NSW RURAL FIRE SERVICE

Your reference: SSD-9794683
Our reference: DA20201020003854-Response to
Submissions-1

State Significant Development - Warehouse or Distribution Centre

Oakdale West Estate Stage 3 Development- SSD-9794683 2 Aldington Road Kemp's Creek NSW 2178, 26//DP1269741

Figure 2: Revised site plan – Building 2A (Source: SBA Architects)

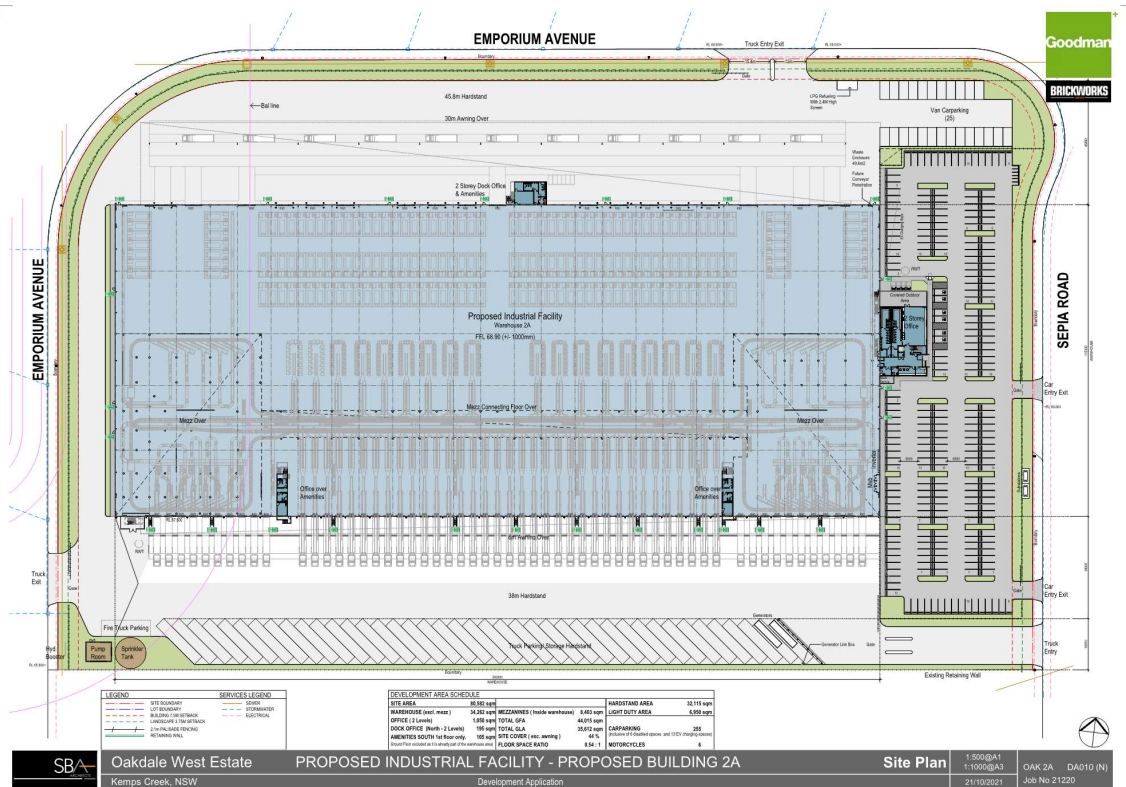
3. New construction of the warehouse building 2A must be entirely non-combustible materials only and provided with measures to improve ember protection.

Ember protection improvements are achieved by enclosing all openings (excluding roof sheet and tile spaces) or covering openings with a non-corrosive metal screen mesh with a maximum aperture of 2mm. Where applicable, this includes any subfloor areas, openable windows, vents, weep holes and eaves. External doors are to be fitted with draft excluders.
